6 May 2009

**APPLICATION TO MODIFY PROJECT APPROVAL NO. 08-0049
SYDNEY WATER FACILITY, POTTS HILL RESERVOIRS SITE**

**North + East Elevations  
Warehouse & Warehouse Office**

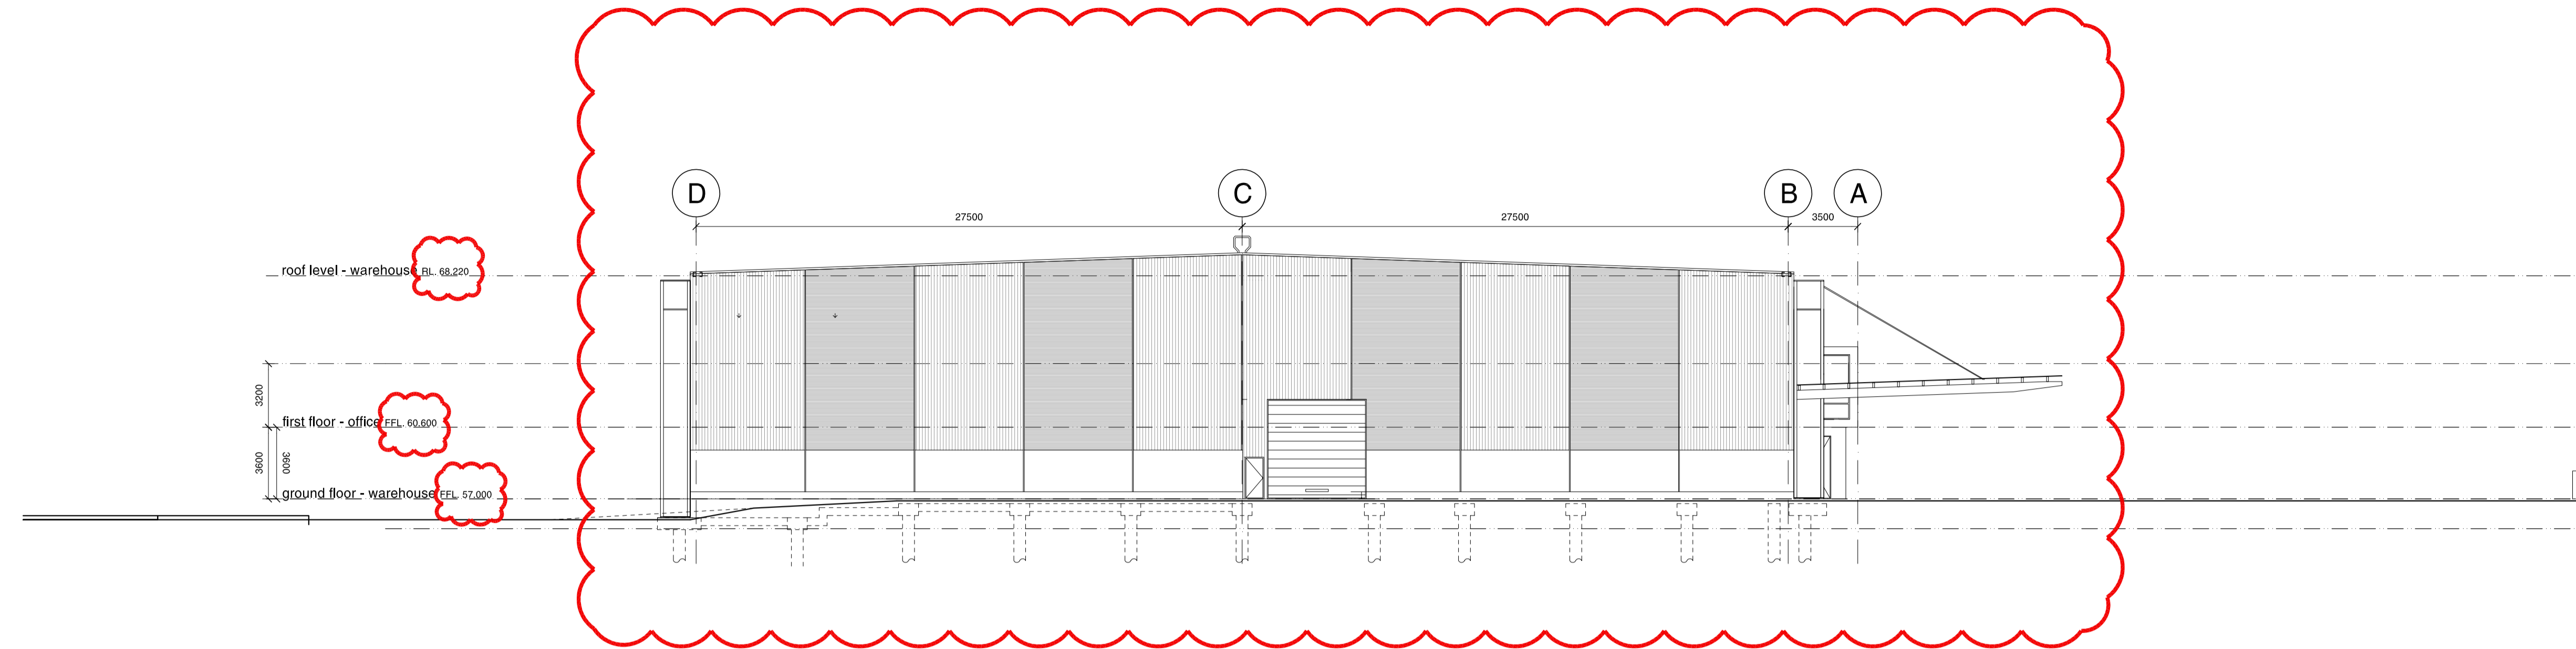
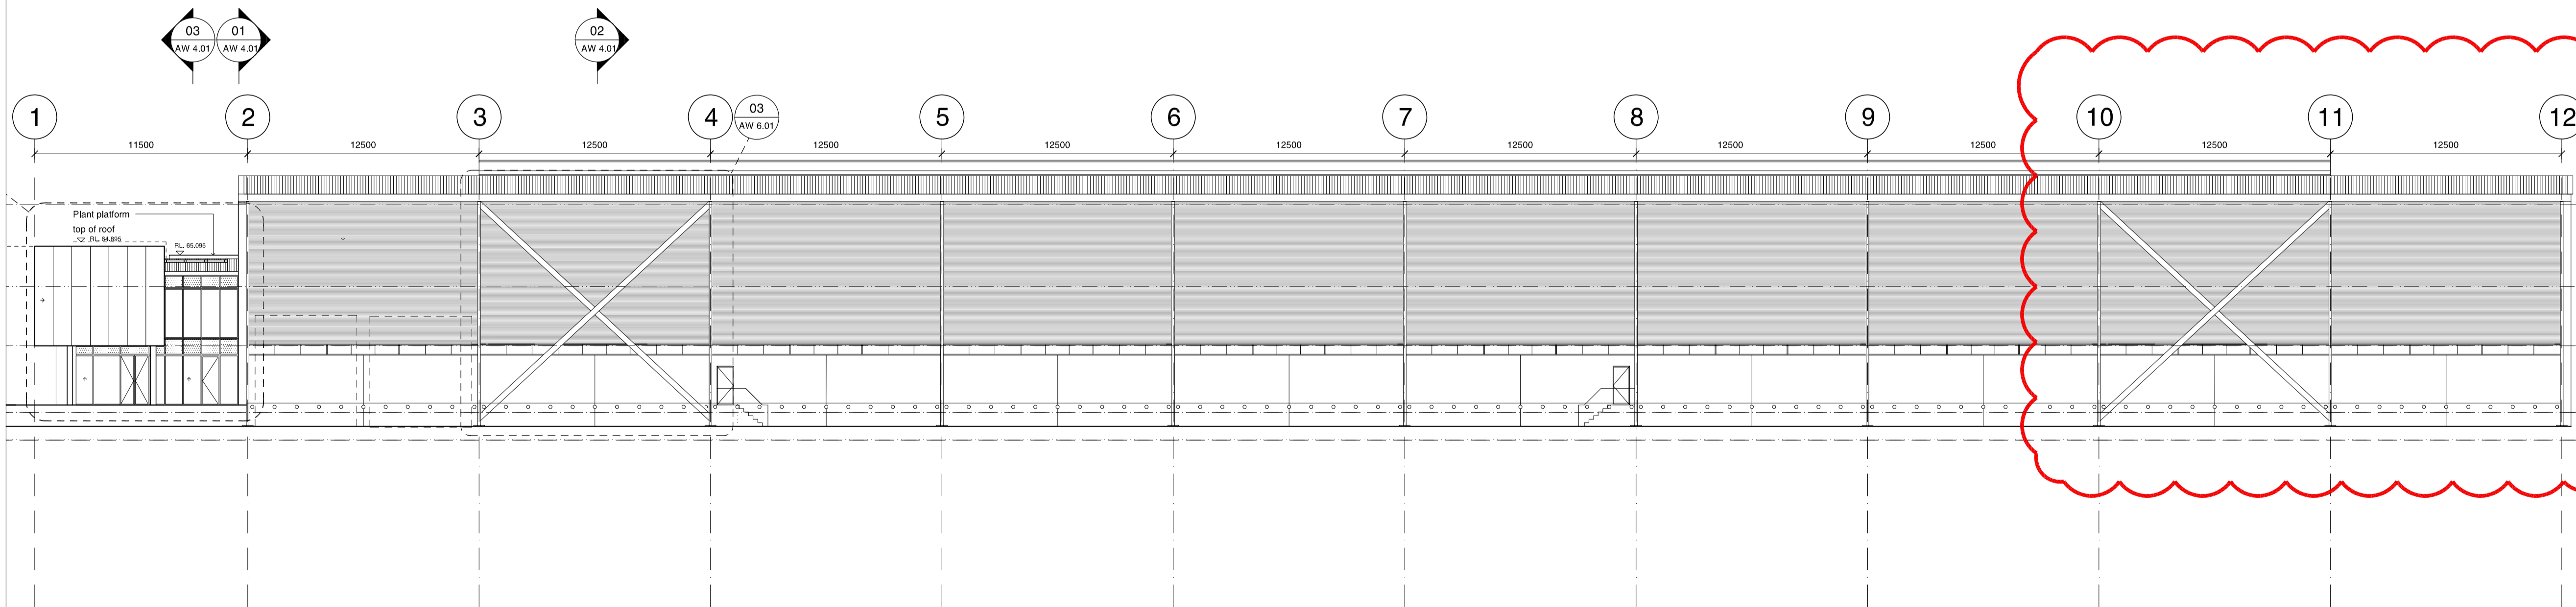
Warehouse materials

At the time of the DA (June 08) the east and west elevations of the Warehouse had a pre-cast concrete portion up to approx 2.0m high, with metal cladding above that. The north and south elevations did not feature precast concrete. Precast to approx 2.0m high has now been added to the north elevation, and the south elevation (which is the Warehouse Office) has precast cladding part of the ground floor. The predominant material of the warehouse elevations remains metal cladding.

Sydney Water
 Potts Hill
 Truck Wash / Storage Sheds
 Plans

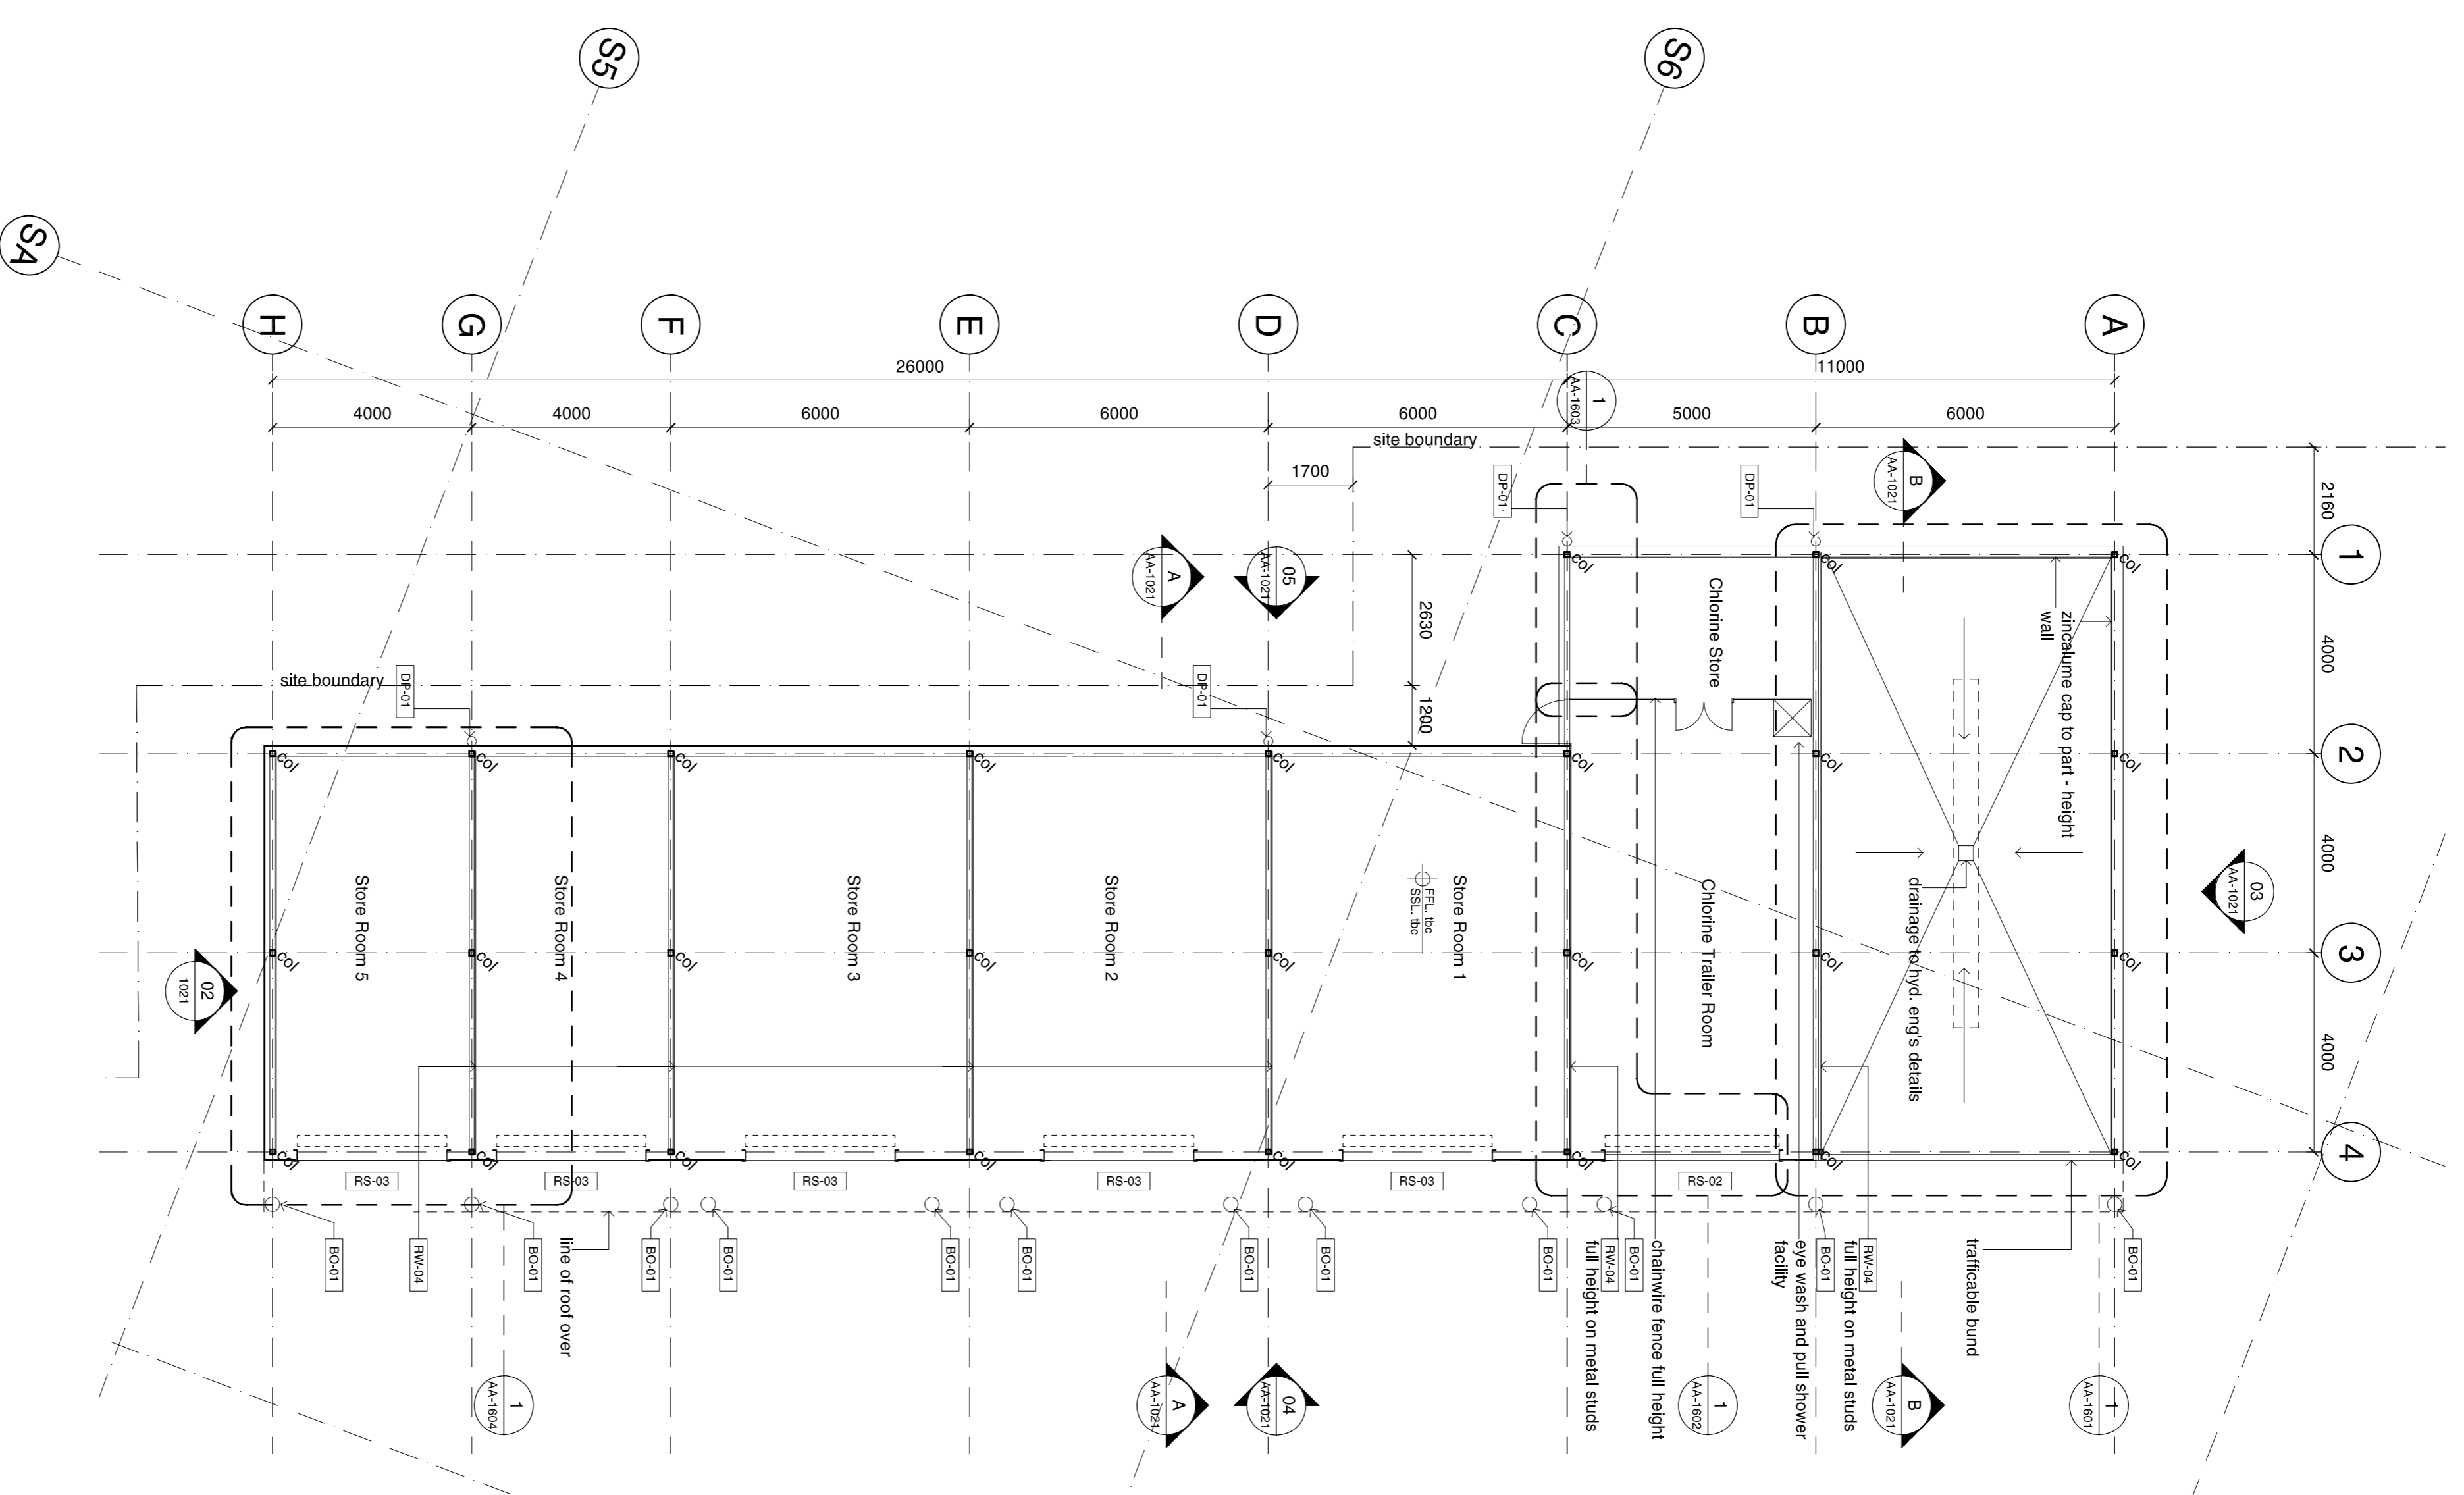
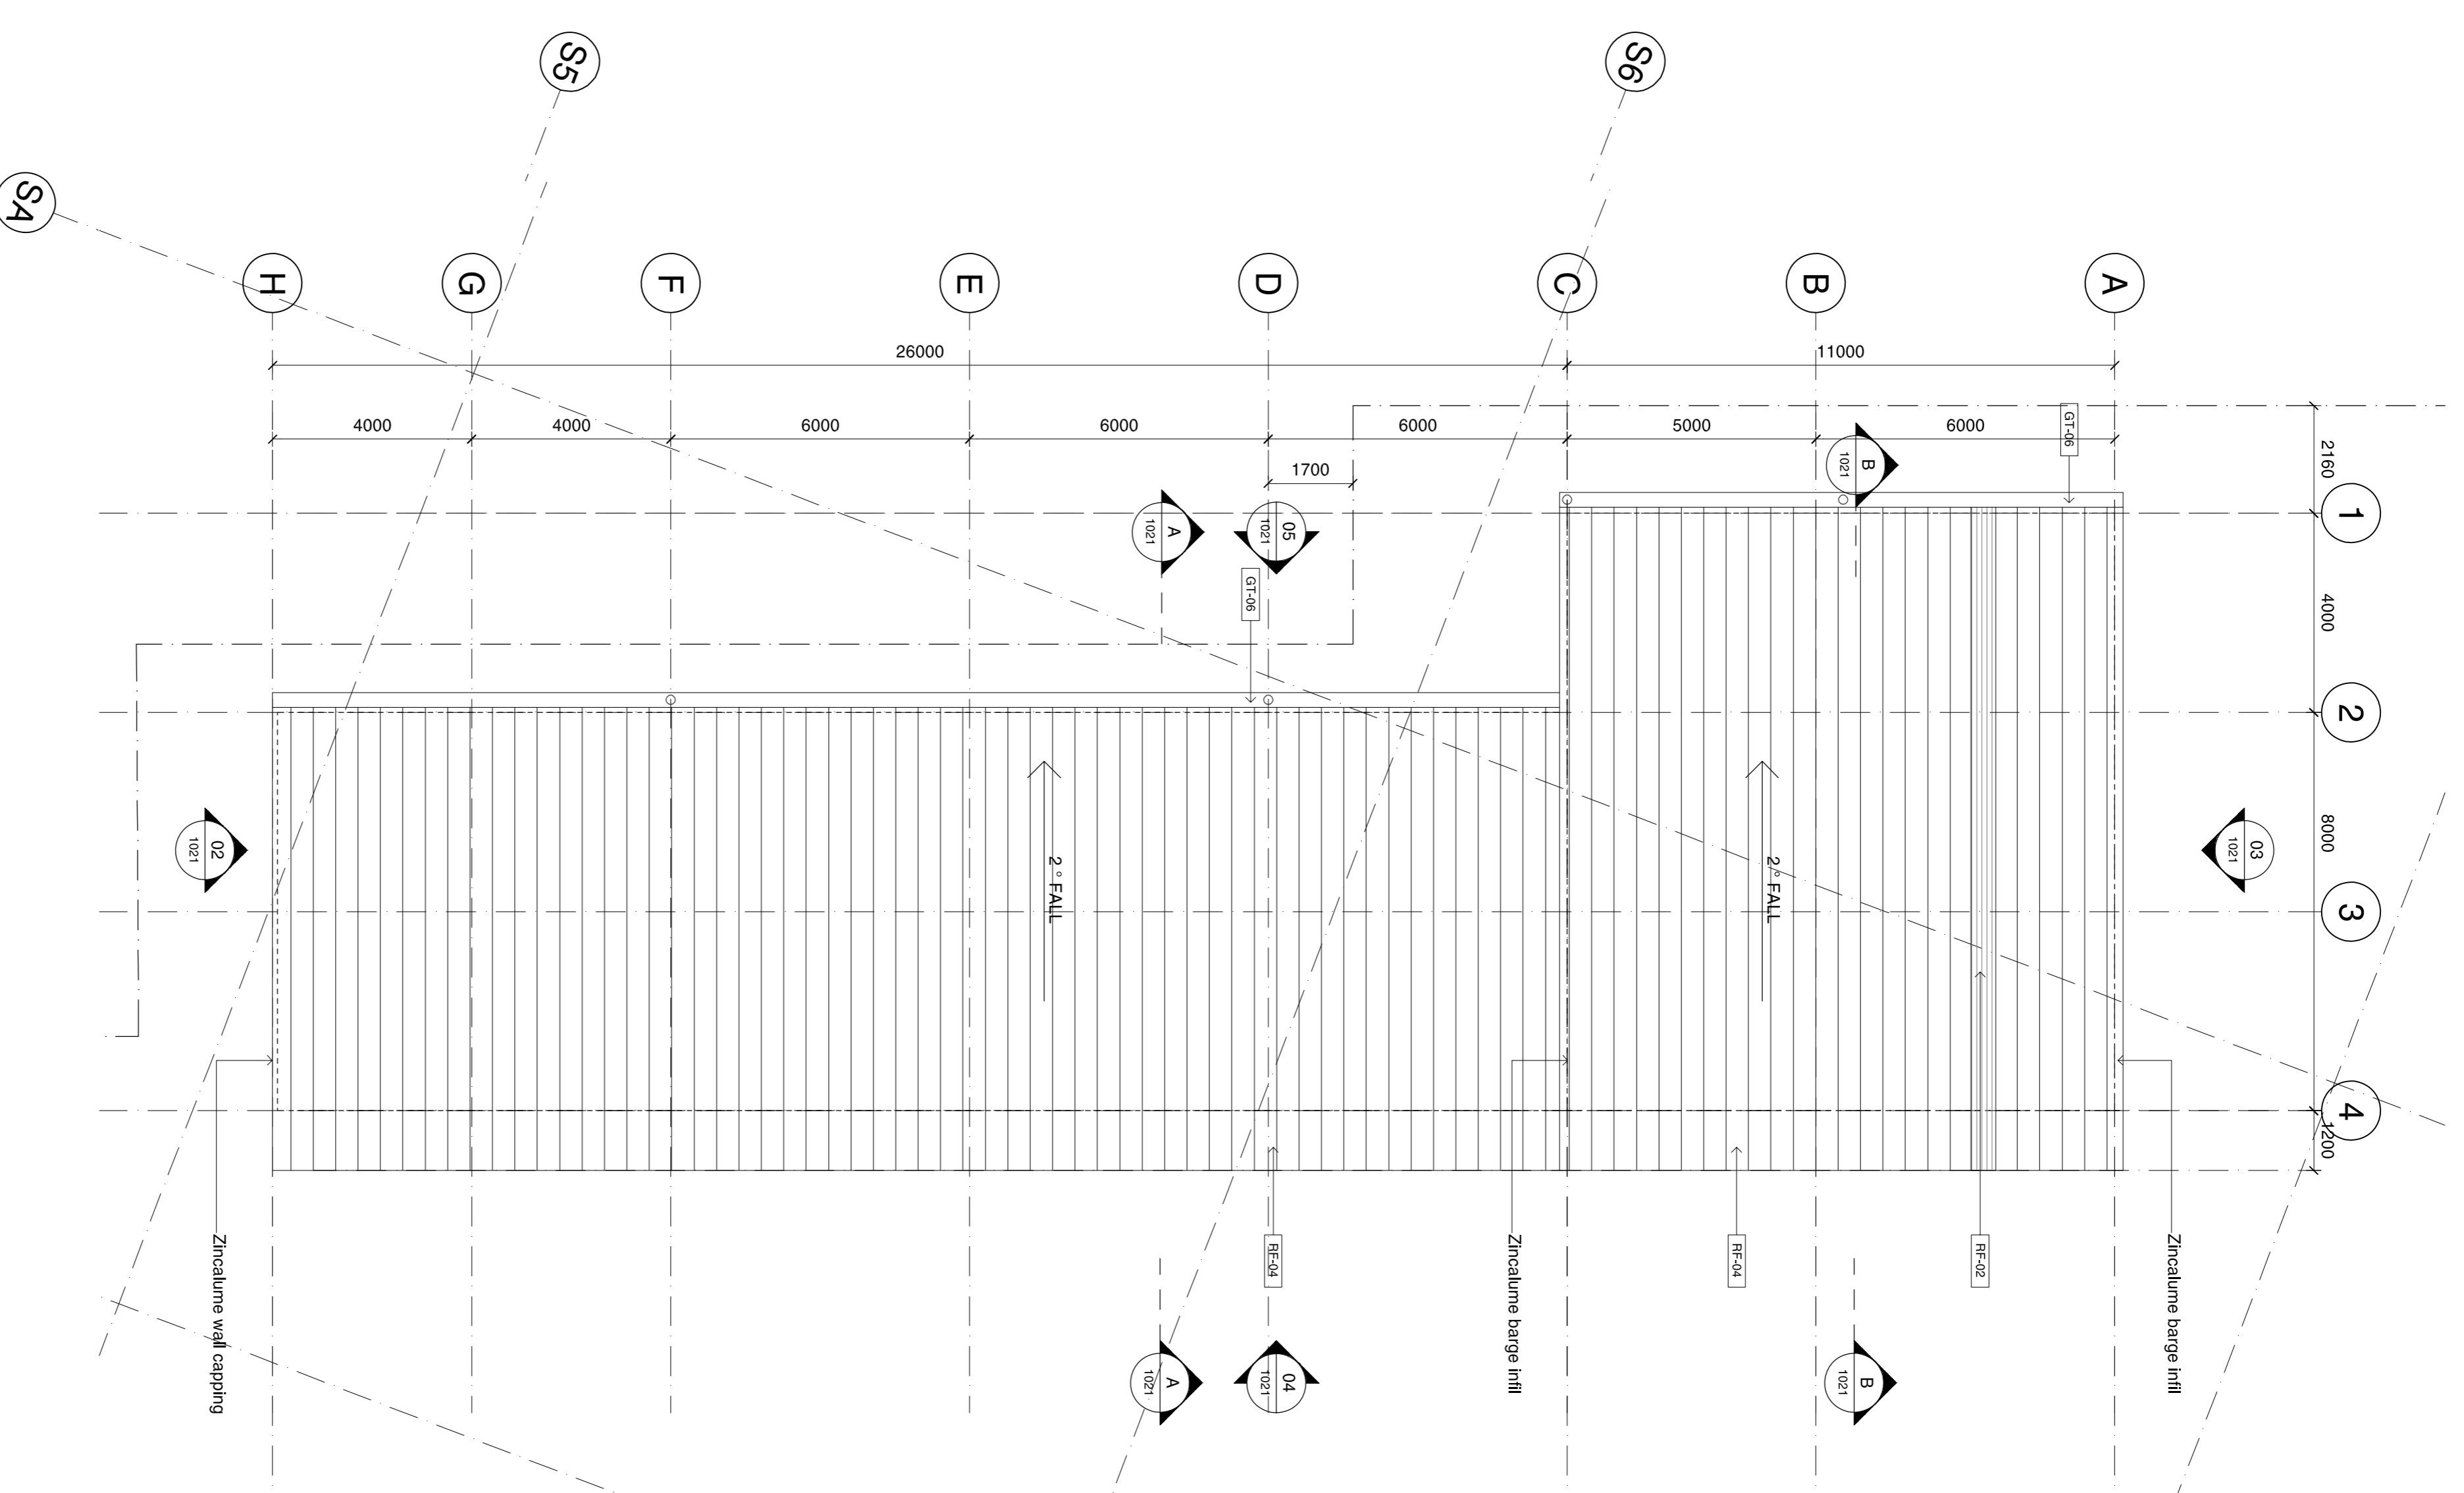
Storage Sheds

The western storage shed drawings have now had heights added to show slab and roof RL's. The materials for the building are zincalume (ie silver colour) metal cladding to all elevations and light grey Colorbond to the roof. The floor level of the proposed western storage shed is approximately equal to the adjacent heritage sheds, with the external hard-stand slabs falling away from the new and existing sheds to stormwater drainage. Stormwater from the roof of the proposed western storage shed is carried via gutters and downpipes into the underground stormwater system. Drainage is designed so that there will be no impact on the heritage sheds.

The proposed shed has a maximum building height of 6.56 metres, rising from a FFL of RL57.10m. However the top of the roof of the majority of the building, including that part closest to the heritage sheds, is 4.52 metres in height.
